HTE# BRES 2303-0071

EXISTING SEPTIC SYSTEM INSPECTION

PURPOSE OF INSPECTION: 14x25 Attached Garage
The aforementioned site has been evaluated by the Harnett County Health Department Environmental Health Section. At the time of inspection, there appeared to be a septic system serving this site. If this system should malfunction, the owner is responsible for any necessary repairs.

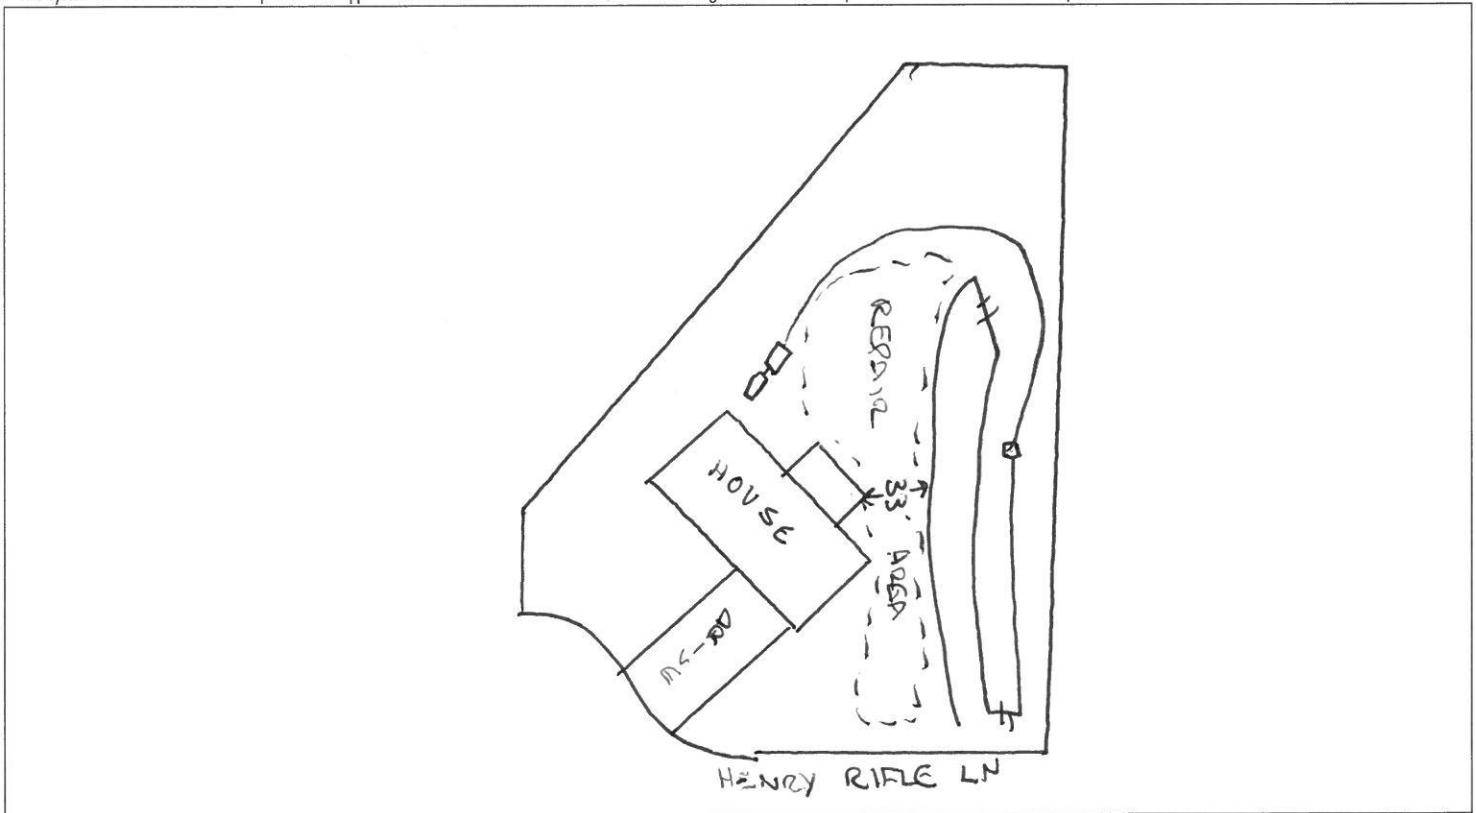
* Will change Repair AREA
to True 50% REDUCTION
* BUSH/TREE NEEDS
Removal From
on top of
Pump Tank + Control

**BUILDING MUST BE 5' FROM ANY PART OF SEPTIC SYSTEM
DO NOT DRIVE OR PARK ON SEPTIC SYSTEM**
